Our Ref: 21/00785/FUL

APPLICATION NO: 21/00785/FUL

PROPOSAL: Proposed two storey rear extensions to form additional living space, covered walkway over existing wall and existing garage rebuilt as entertainment room. Alteration to planning approval 20/01768/FUL.

LOCATION: Willow Green Cottage Colchester Road Thorpe Le Soken Clacton On Sea

Existing ground floor layout

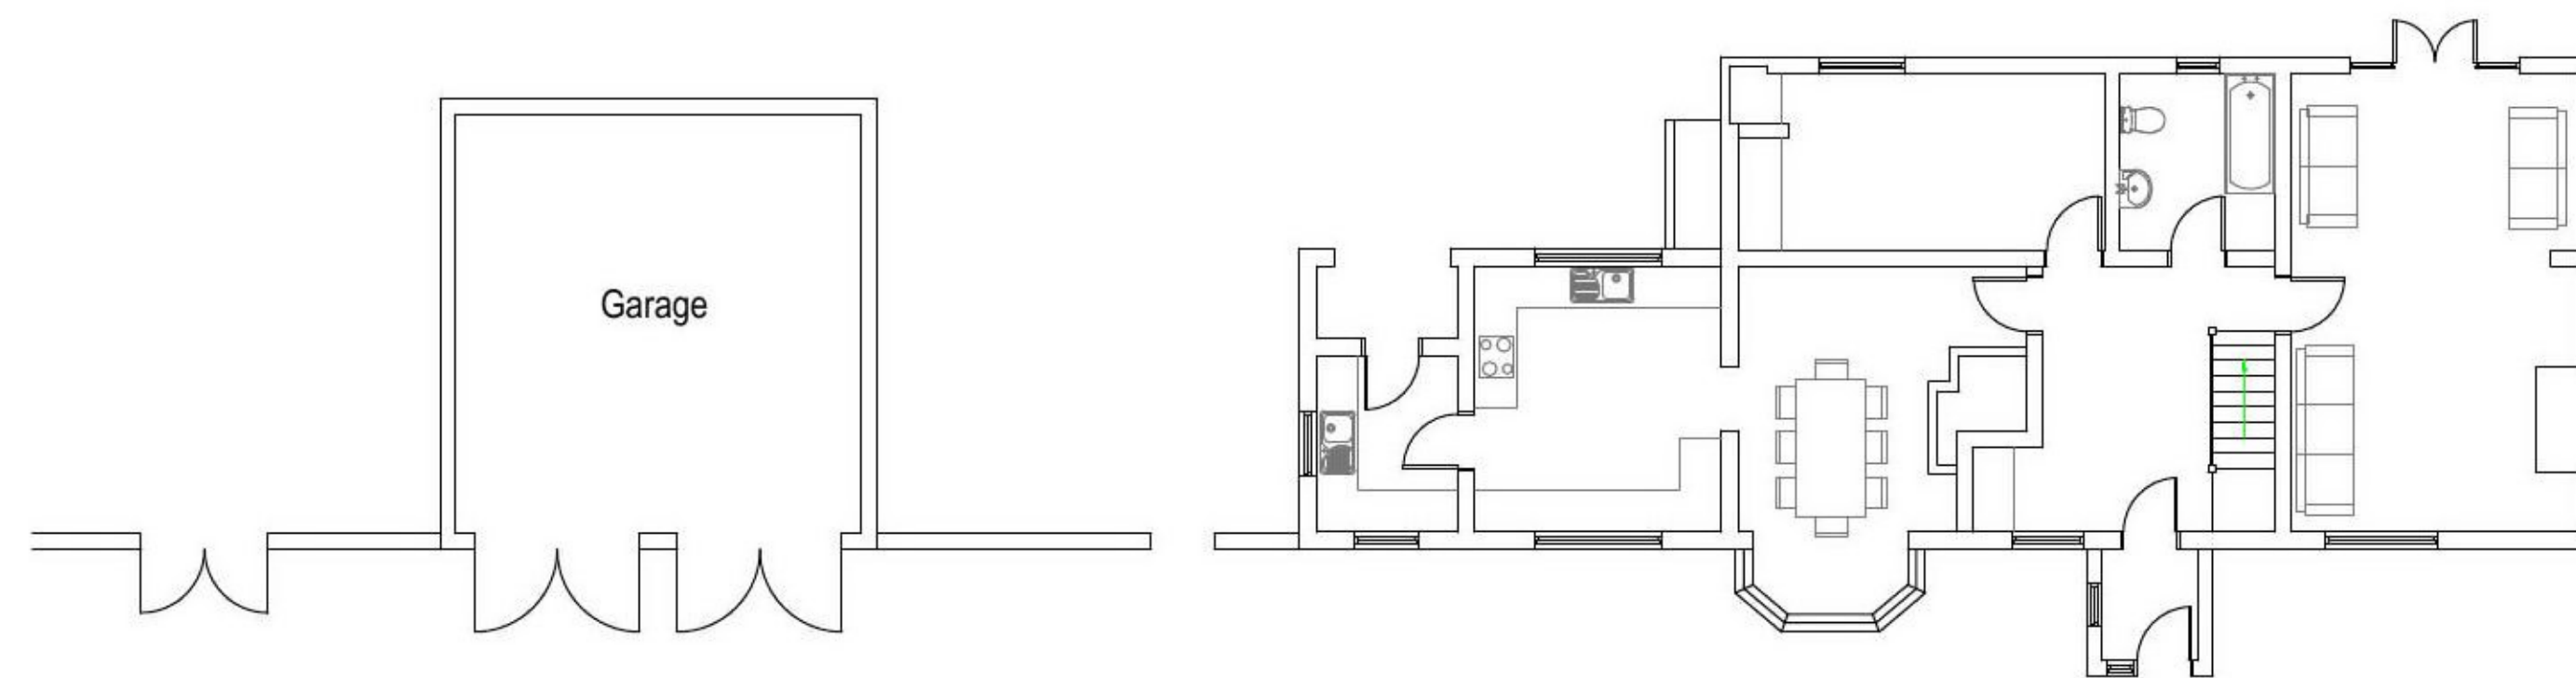
04 The existing garage on the block plan does not match in measurement to the garage shown on the existing floor plan. Please amend.

05 The proposed entertainment room on the block plan does not match in measurement to that shown on the existing floor plan. Please amend.

Existing Block plan 1:500

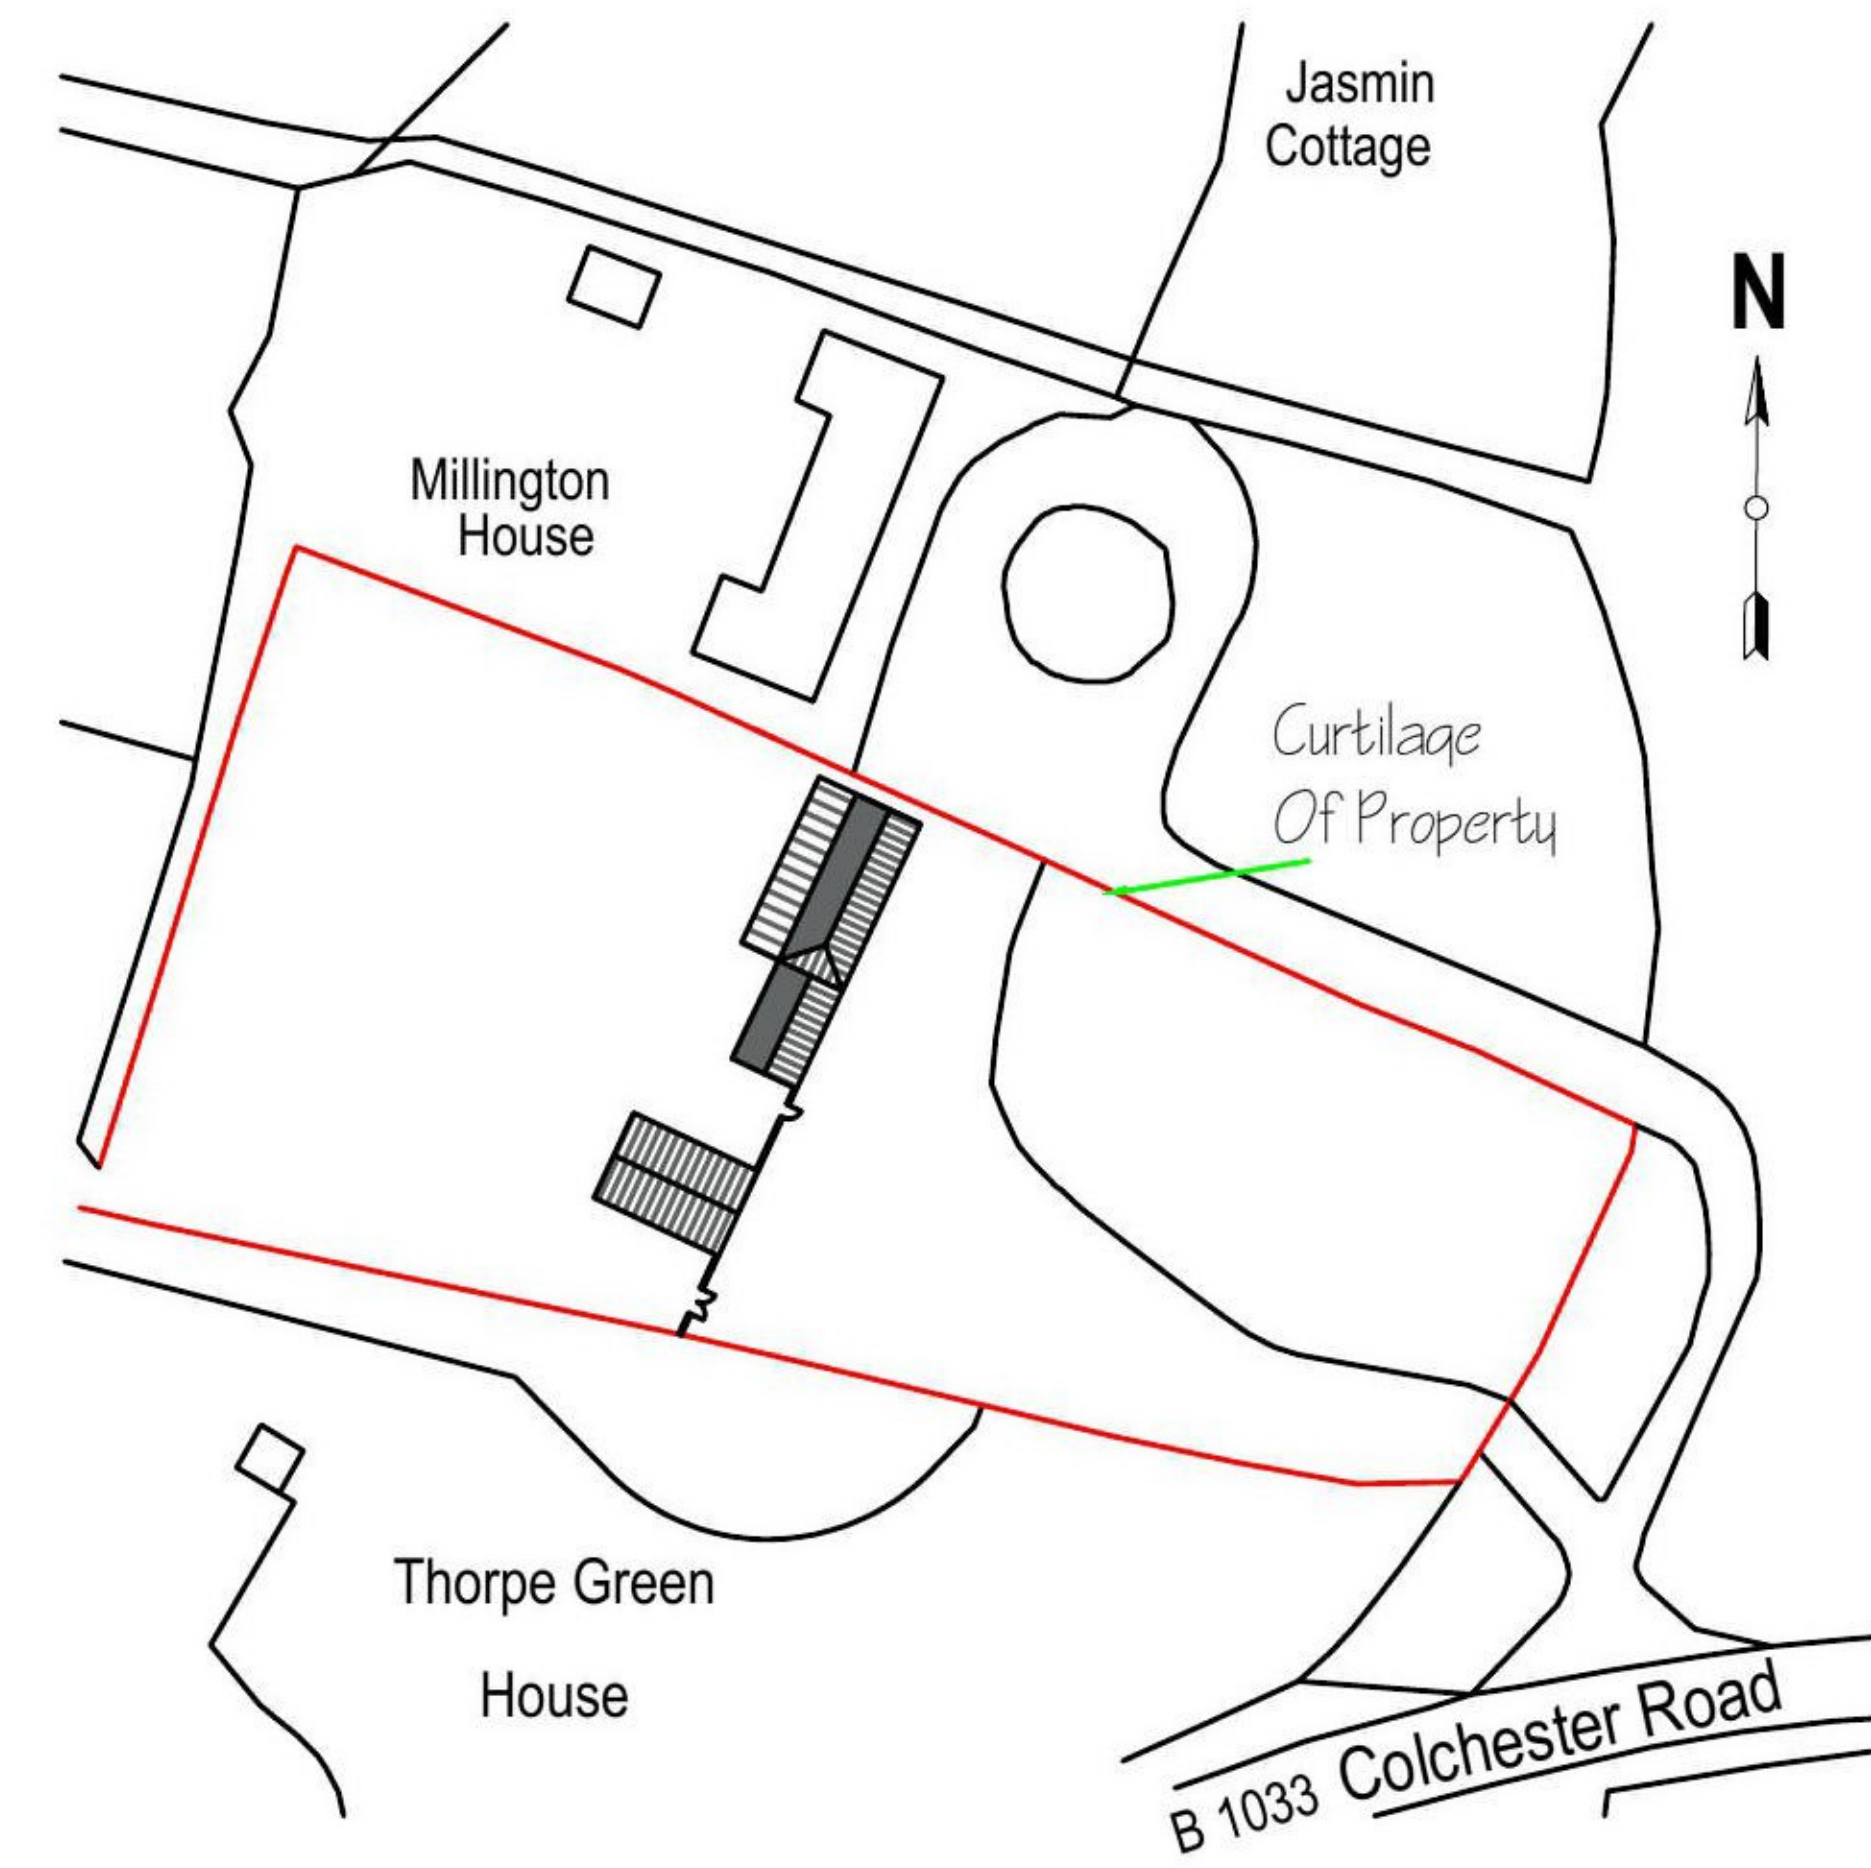
03 The red line on the site plan and block plans are incomplete. Please amend the plans so the red line joins at all four corners.

Proposed rear elevation

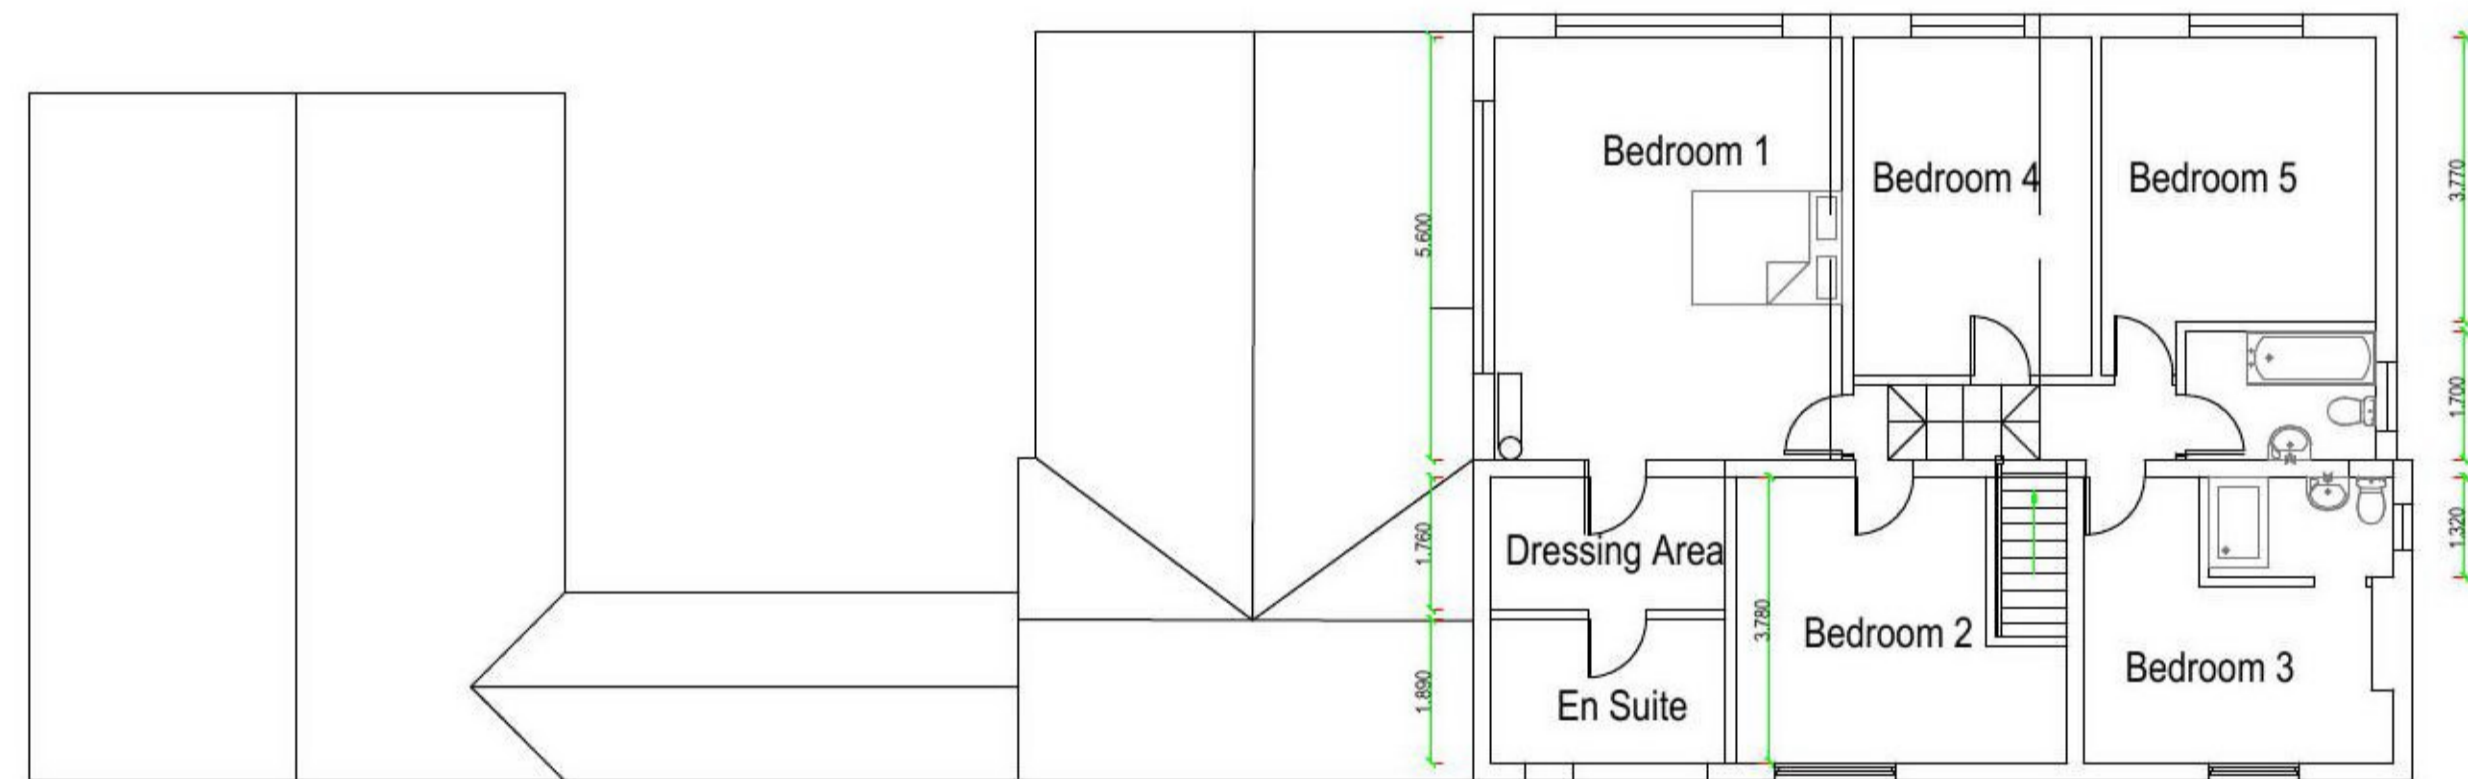
06 The proposed rear elevation shows a door and window serving the entertainment room that is not shown on the proposed floor plan. Please amend.
